# CITY OF ALBUQUERQUE

**RE: Lot 8 Block 2 Unser Cliffs SAD 227  
6704 Rim Rock Circ. NW  
Grading and Drainage Plan  
Engineers Stamp Date 3/25/2023 (D10D025)**

Based upon the information provided in your submittal received 4/17/2023, this plan cannot be approved for grading until the following comments are addressed.

6704 RIM ROCK CIR NW
GRADING PLAN

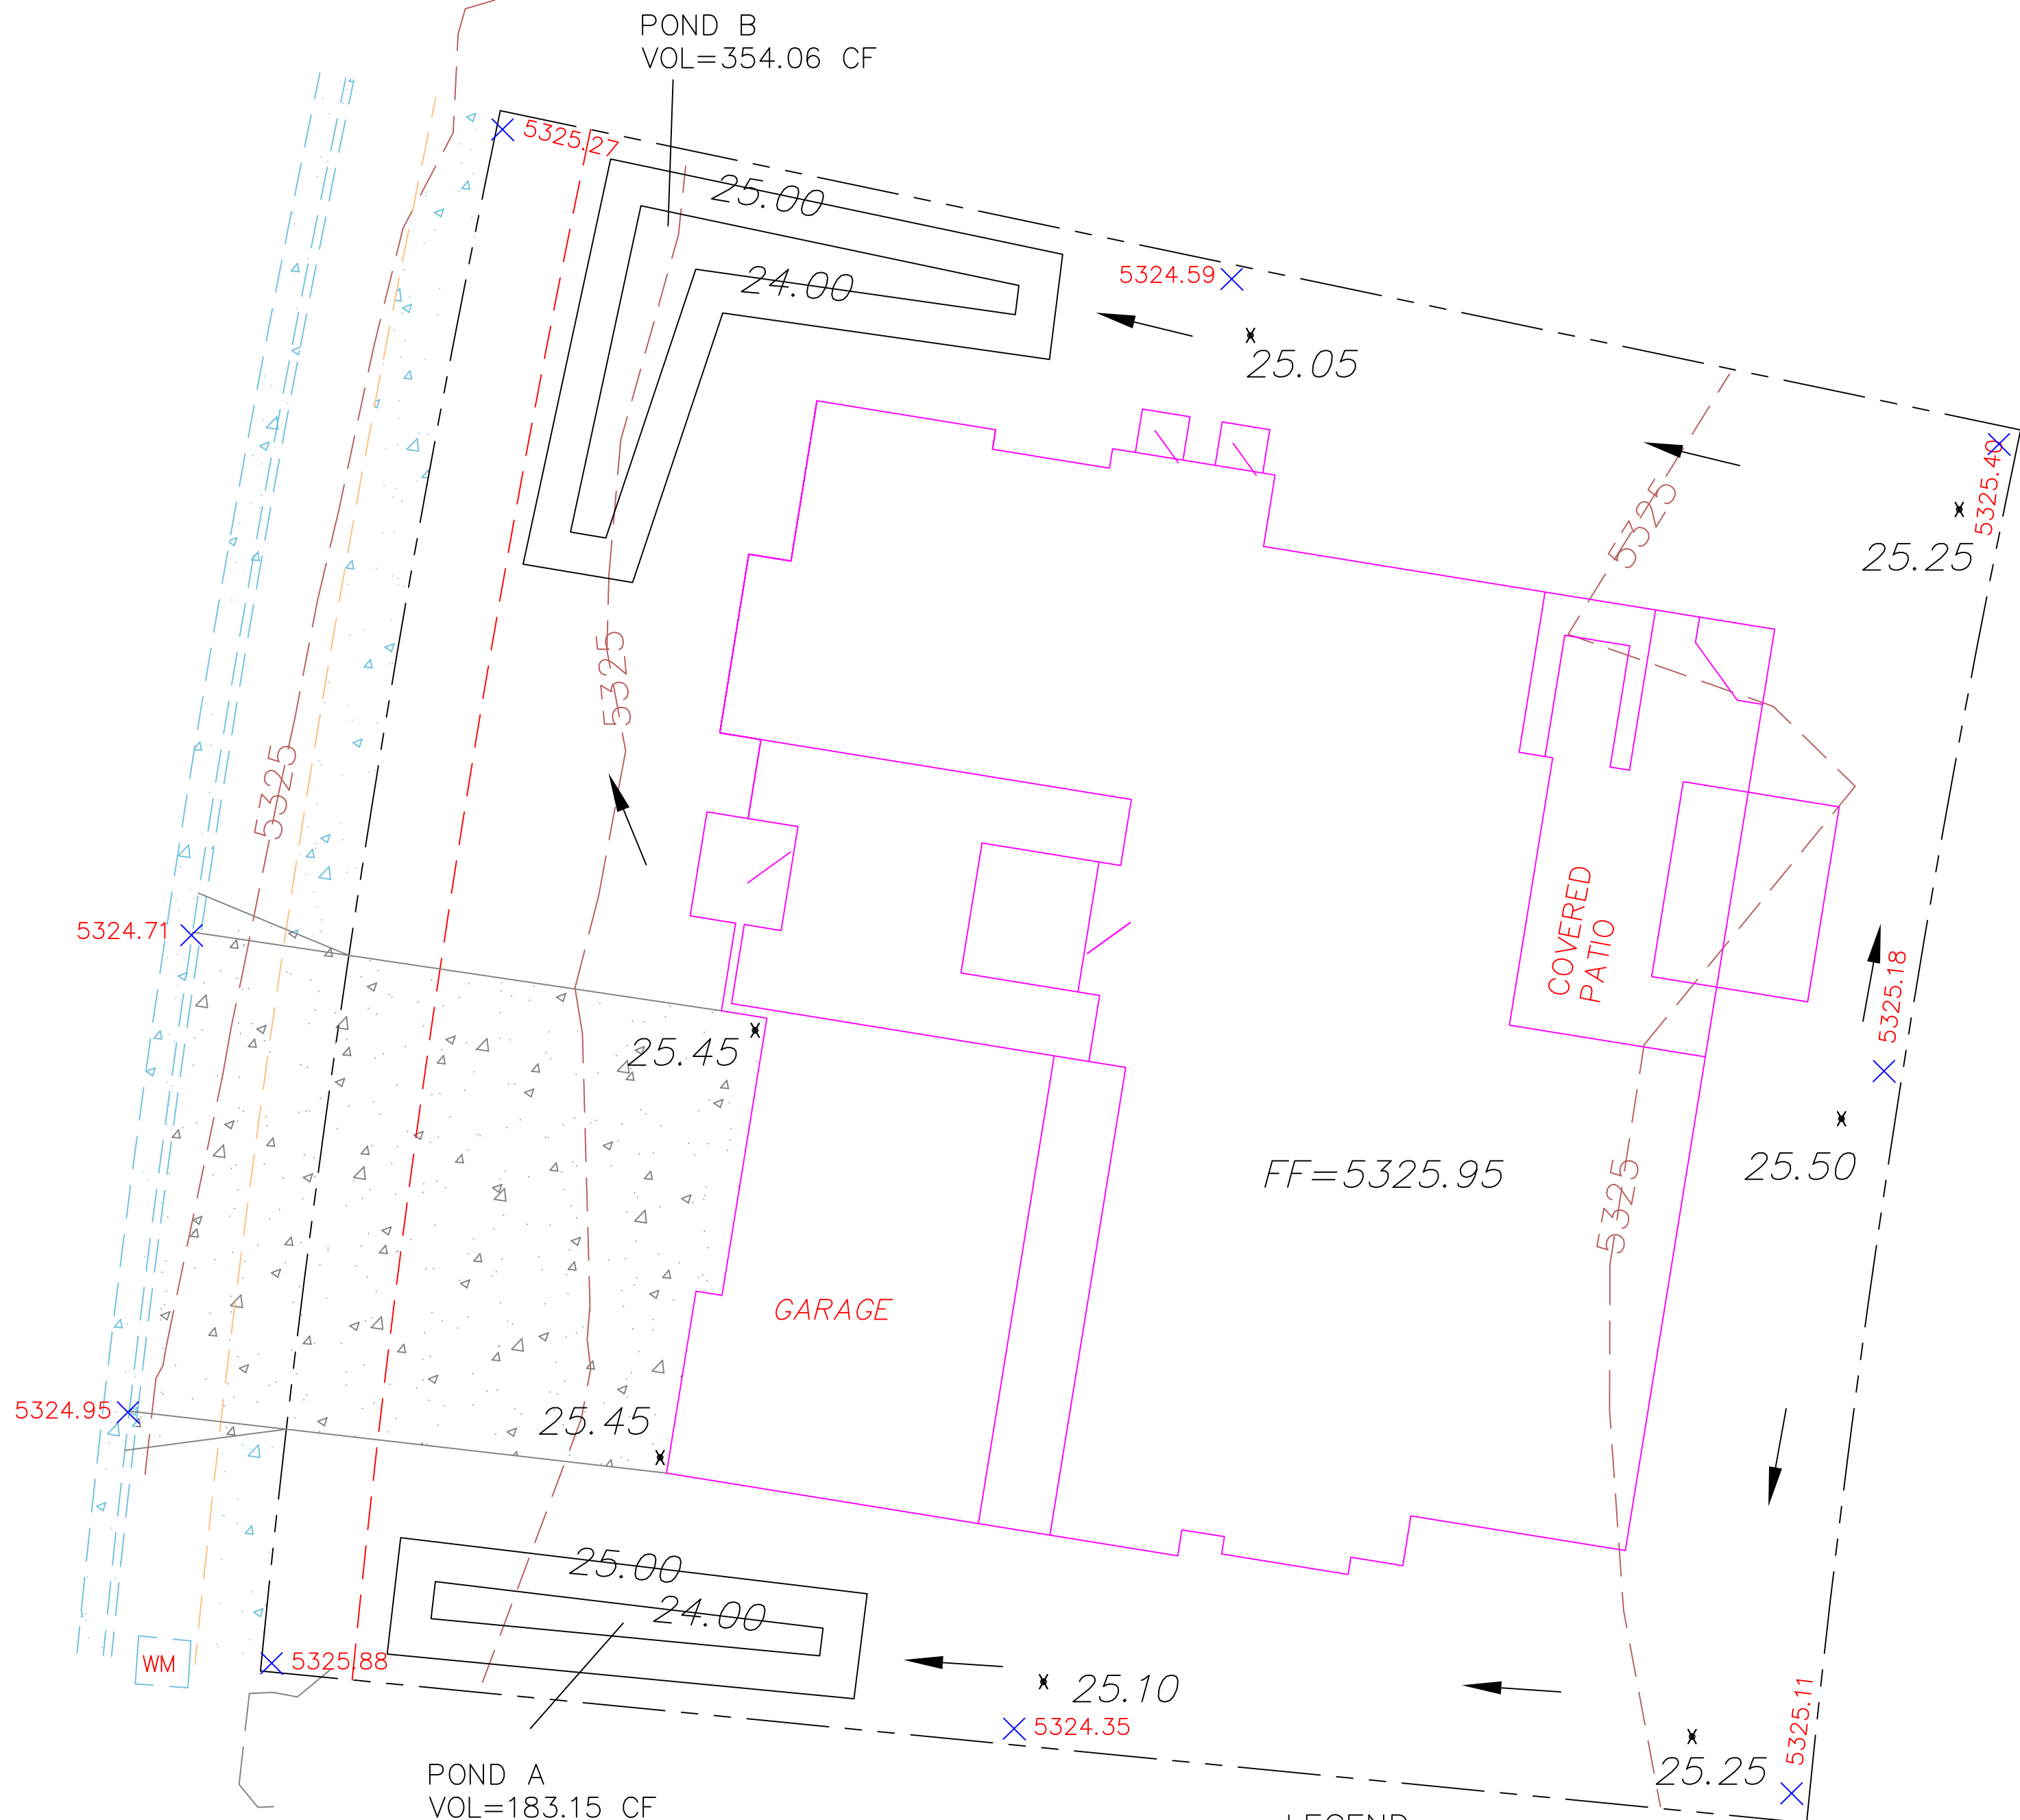
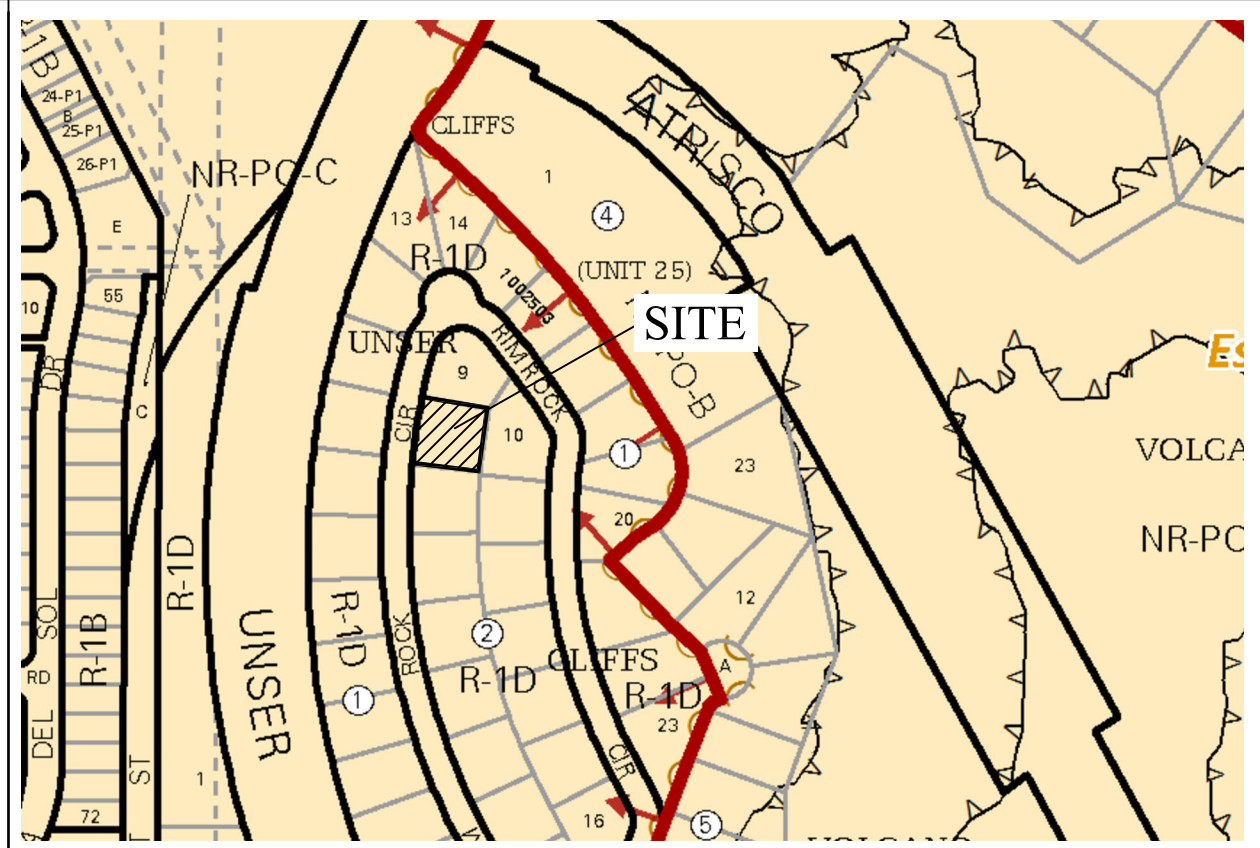
- The building pad cannot be higher than 1 foot above the road elevation, unless there is a reason given on the plan as to why it must be higher than 1 foot.
- Provide a table of land treatments for existing and proposed.
